**NorthConnex Application Number: SSI 13\_6136**

Please find below my/our submission in response to the exhibition of the EIS for NorthConnex.

M1-M2-5000-DR-UD-0556
NORTHERN VENTILATION FACILITY - LONG SECTION

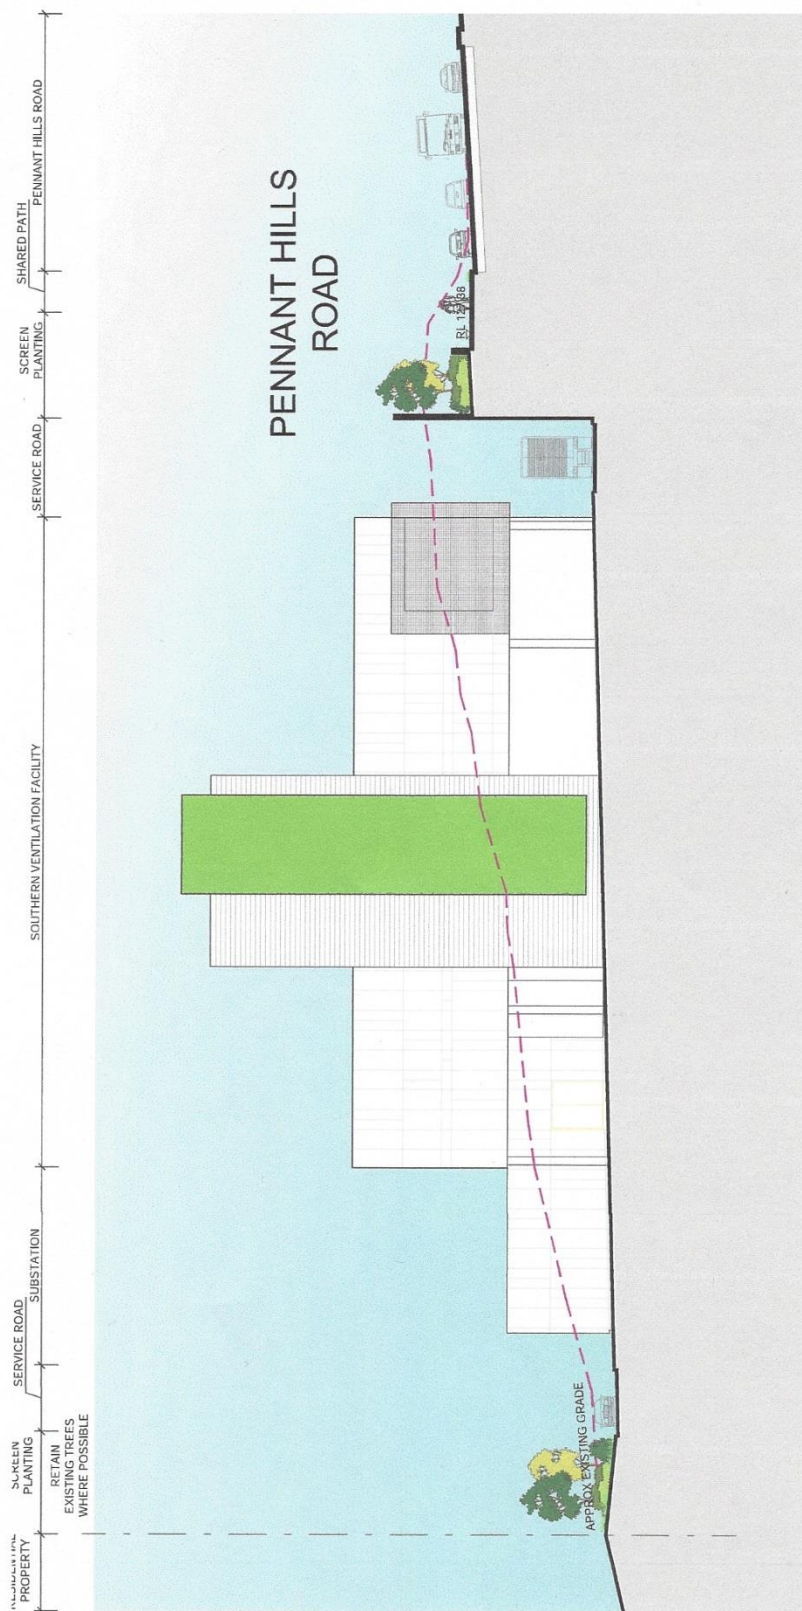
The placement of the northern ventilation stack is in a valley.

When located in a valley such as is proposed for the northern stack, the ventilation stack will increase deposition of particulate matter in the immediate surrounds, as there is less dispersion effect from a stack when placed in a valley.

The valley that is the proposed site for the northern ventilation stack is surrounded by dense vegetation of a height of approximately 20m especially to the south and western sides where the valley is at its greatest depth.

The height of the valley ridges will detract from the height of stack. This results in poor dispersion and in an accumulation of particulate matter in the area around the stack. The dispersion effect of a ventilation stack is dependent on its height, meteorology, topography of the surrounding area, and the levels of in-tunnel vehicular emissions. A valley such as the site in Wahroonga has typically stable air (little turbulence) which further decreases dispersion effects.

The current stack is only 15m high, located in a valley, therefore, for 9km tunnel this is too low to enable the pollution to push through an inversion layer. It is in a valley with houses further up the road being equal in height to the top of the ventilation stack.

*Locate the northern ventilation stack on higher ground.*

*Increase the height of the stack to at least 70m to enable effective dispersion.*
